Application Ref:	3/2025/0344			 Ribble Valley Borough Council www.ribblevalley.gov.uk
Date Inspected:	N/A	Site Notice:	13/05/2025	
Officer:	MC			
DELEGATED ITEM FILE REPORT:				REFUSAL

Development Description:	Regularisation of conversion of garage to home gym and store.
Site Address/Location:	6 Nab View, Whalley, BB7 9YG

AS BUILT FLOOR PLAN

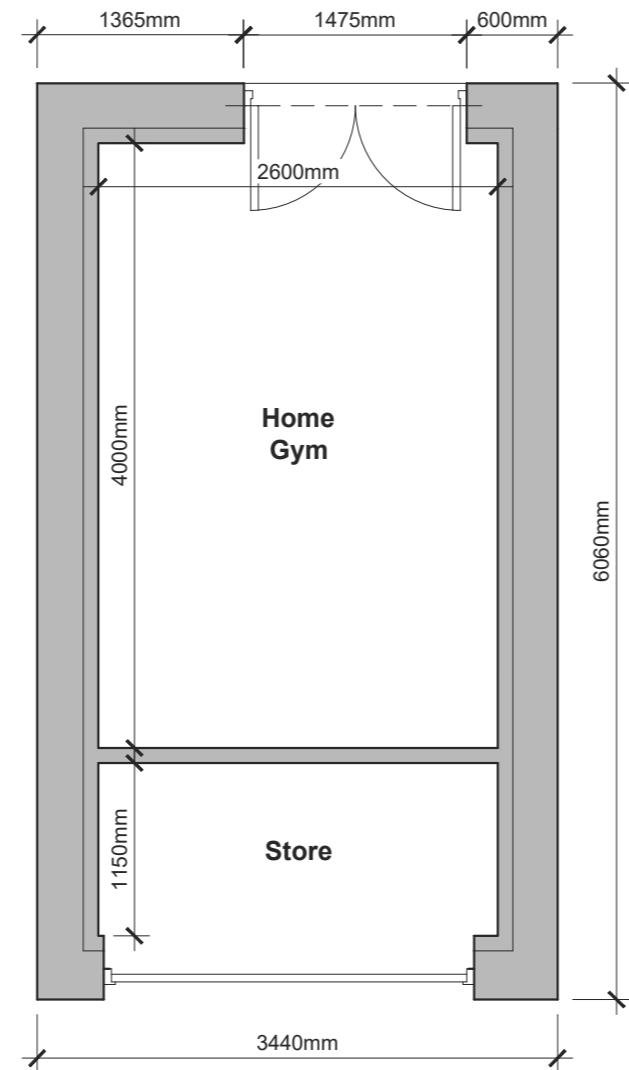
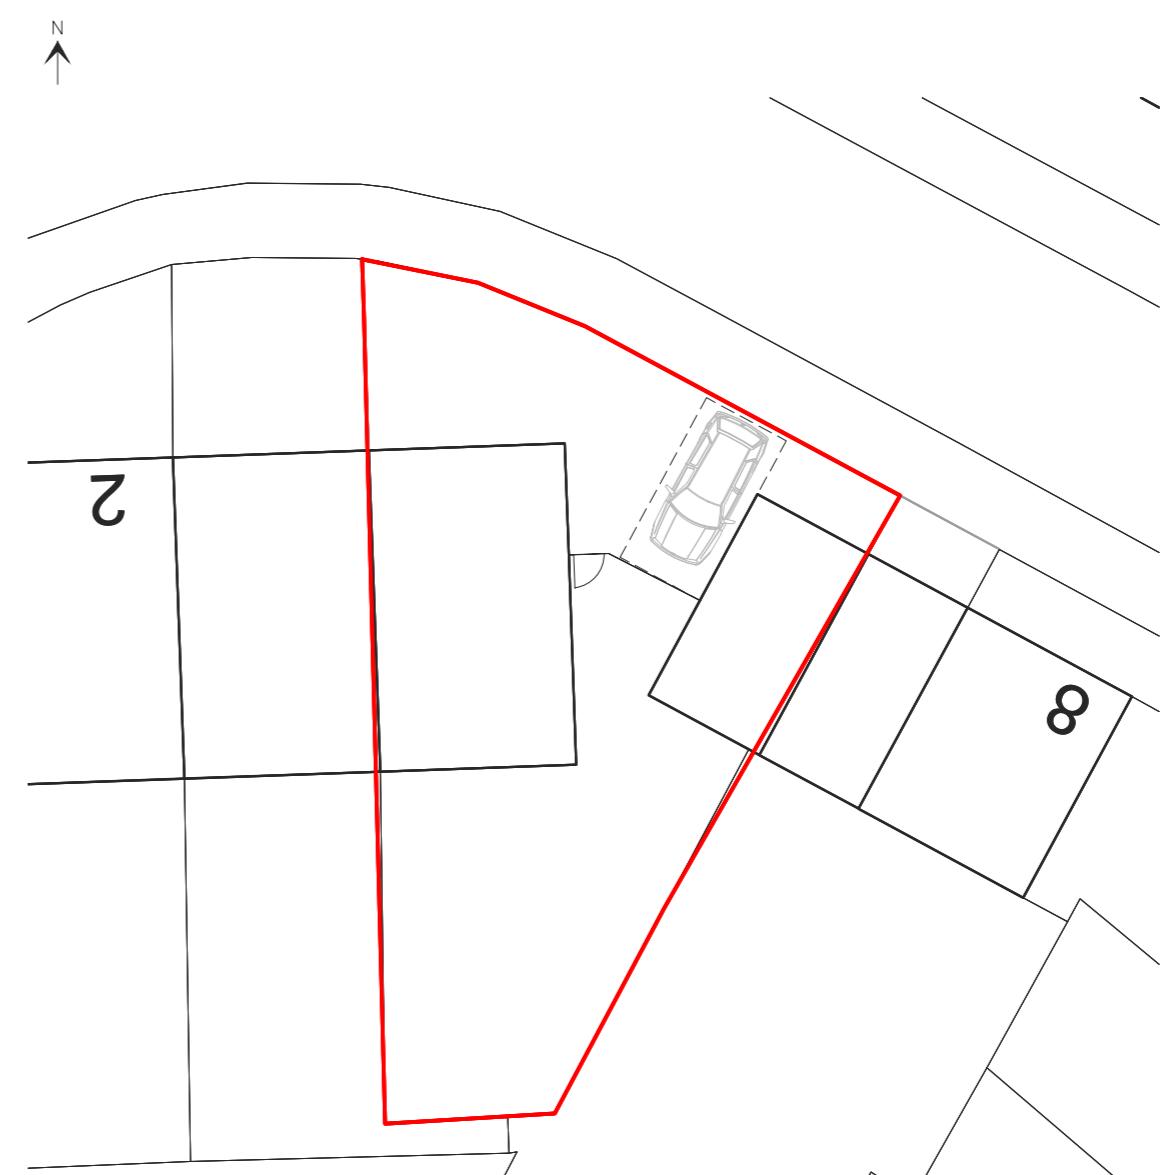
Lancashire County Council as the Local Highway Authority (LHA) have been consulted on the development. The LHA note that the application is retrospective and as per the previous application, they note the garage is substandard in size and would therefore not constitute a parking space or impact on existing parking arrangements, notwithstanding the fact that the 4 no. bedroom property should have 3 no. off-street parking spaces and if the conversion were allowed it would result in 1 no. off-street parking space.

While this may be the case, as per the previous reason for refusal, the Council still consider that the garage configuration prior to the conversion was reasonable to count as a parking space and could house a small vehicle. Whilst a condition was not added to the original planning application to secure the garages for the parking of vehicles, a condition nonetheless was imposed on a previous permission (3/2022/0893) restricting its use to a garage and that condition is still considered to be enforceable. Whilst inward opening patio doors were permitted / installed in the rear elevation, these doors could be kept shut when a vehicle is parked inside therefore not inhibiting the amount of available space. The Council disagree with the views of the LHA and consider that the if the permission were to be allowed, there would be an under-provision of parking spaces for the existing dwelling with a reliance on on-street parking to the detriment of highway/pedestrian safety.

01: The conversion of the garage to a home gym would result in an unacceptable level of parking for the property at 6 Nab View and would result in an increase in on-street parking to the detriment of highway/pedestrian safety, contrary to Policy DMG3 of the Ribble Valley Core Strategy.
